Appeal Decision

Appeal Ref: APP/T2350/W/23/3331604

Lower Barn Farm, Whalley Road, Sabden, Lancashire BB7 9DT

- The appeal is made under section 78 of the Town and Country Planning Act 1990 (as amended) against a refusal to grant planning permission.
 - The appeal is made by Mr Mark Solomon against the decision of Ribble Valley Borough Council.
 - The application Ref is 3/2023/0221.
 - The development proposed is field mounted 20Kwp field mounted solar PV array.
-

PROPOSED SECTION AND PLAN

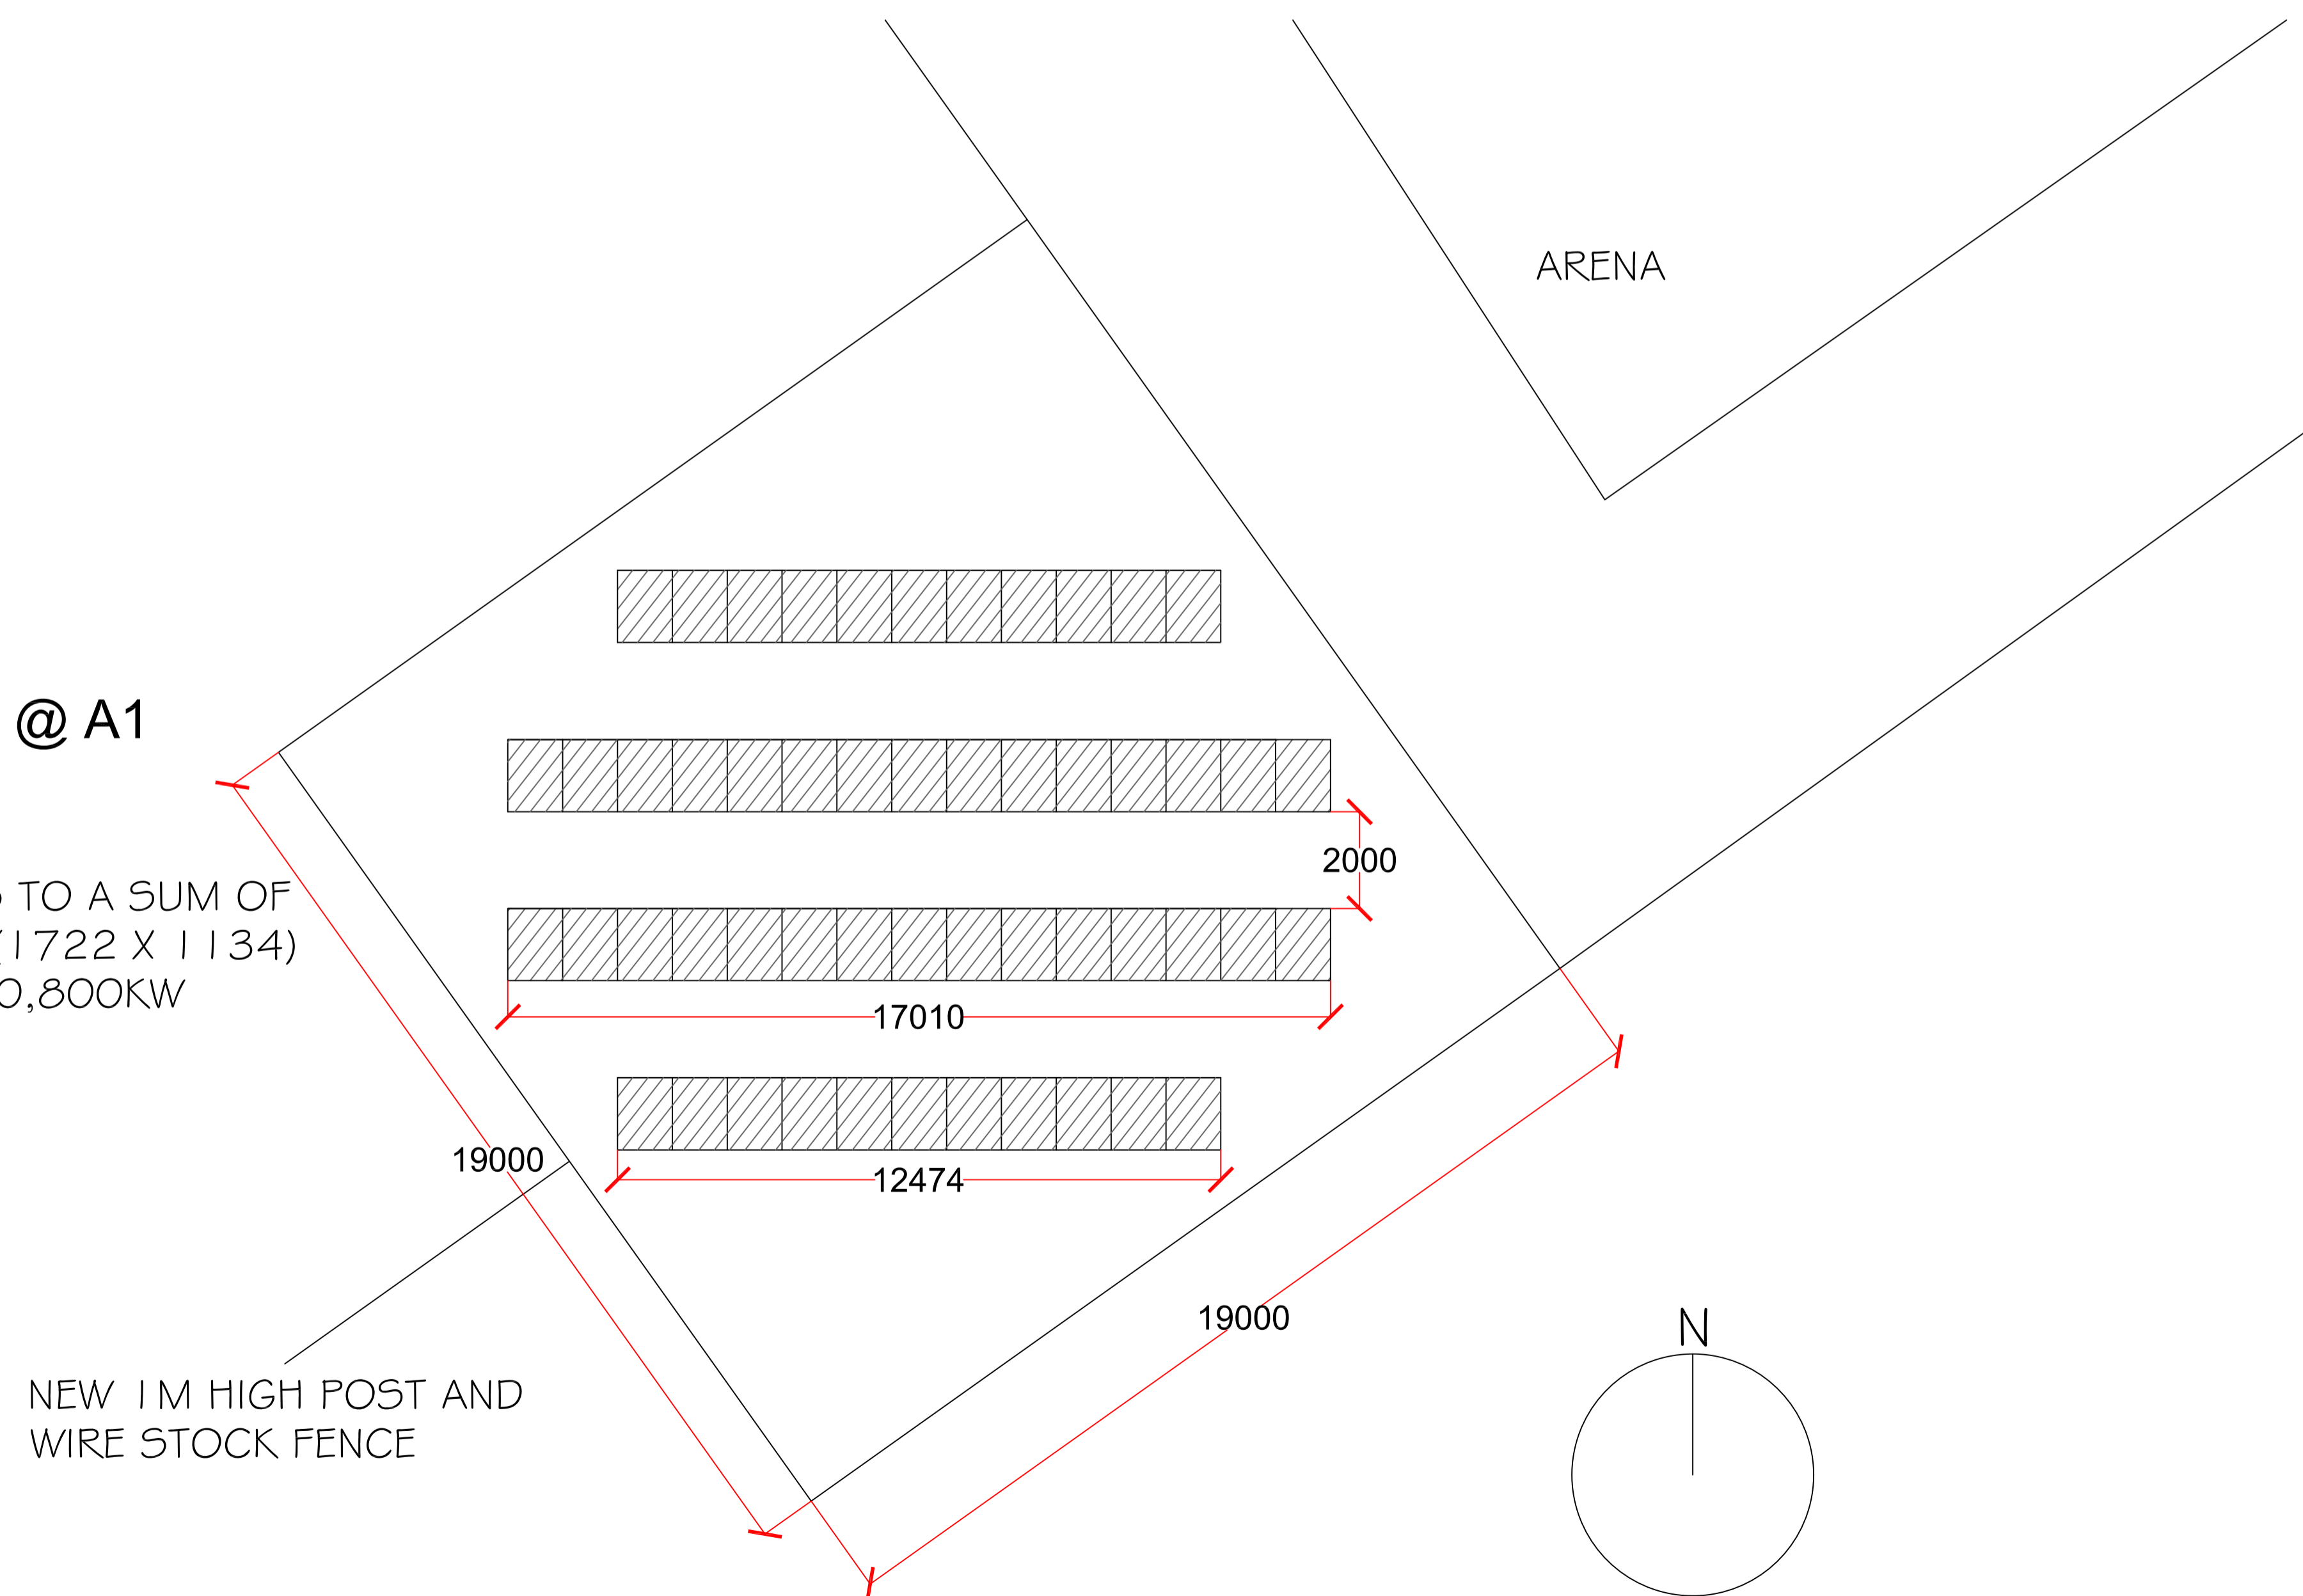
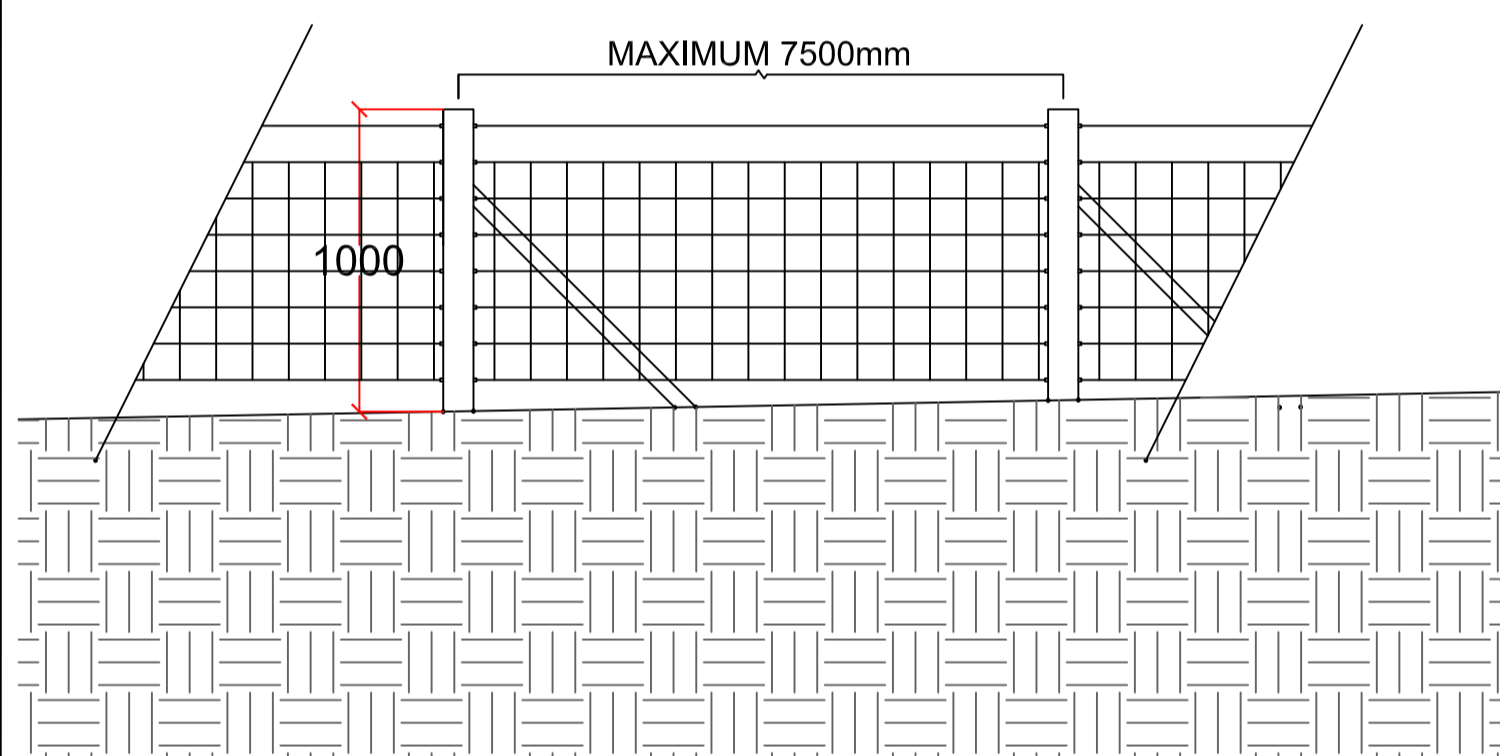
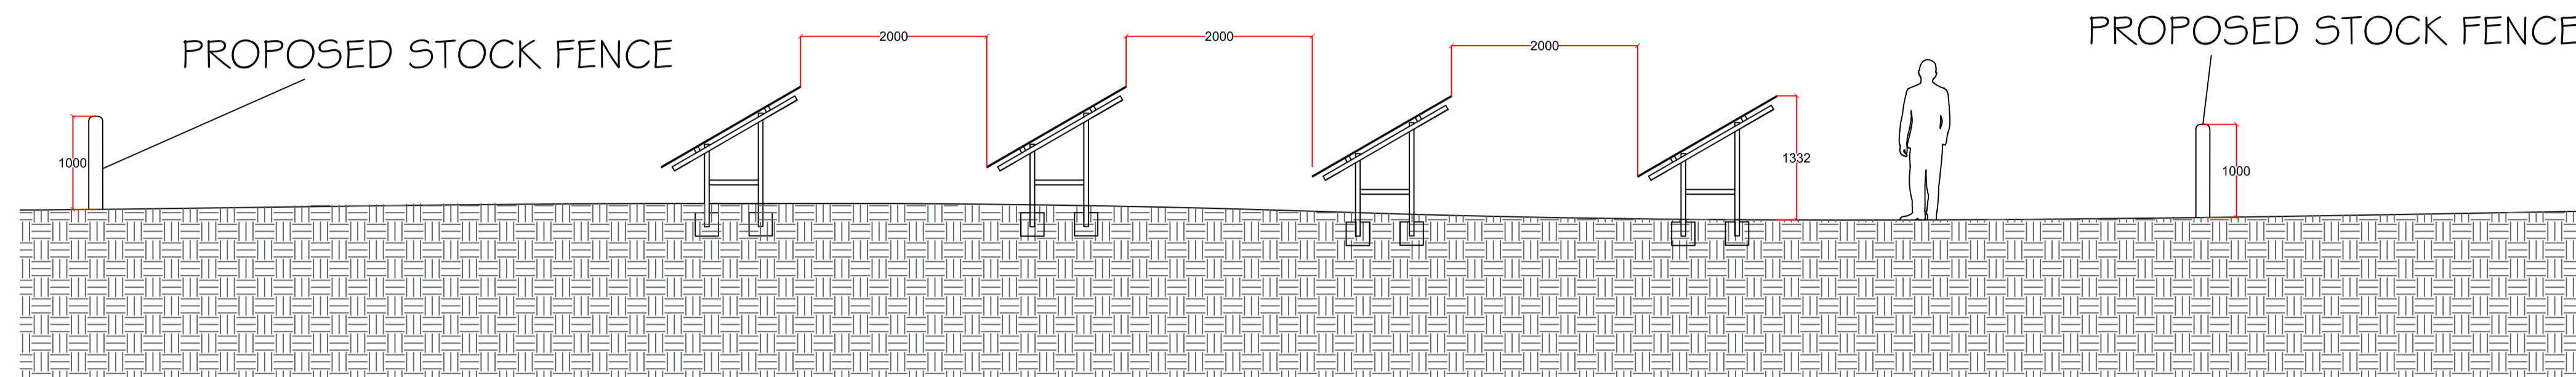
7. Whilst the solar array would not cover a large area of land, it would extend development into the agricultural field, outside and away from the existing buildings and garden area. The layout of the 52 panels, in four rows, plus the introduction of materials, such as aluminium, would appear alien in this location and would harm the gentle, pleasant countryside setting of fields, hedgerows and trees that exist around the site. Whilst the panels would be low in height, they would not harmonise with the characteristics and appearance of the area. Although screening the array would provide some benefits, it would also highlight the size and shape of the site which would appear conspicuous and out of character with the fields and boundaries that surround the site.

13. The solar panels would be sited across a designated PROW, FP0337113. As such, a Diversion Order would be required. Whilst there has been some confusion over the exact location of the footpath on the ground, the definitive map clearly shows that the development proposal would conflict with its location. Whilst the Council's advisor on PROWs has no outright objection to the proposal, this would be subject to the necessary diversion being agreed and implemented.
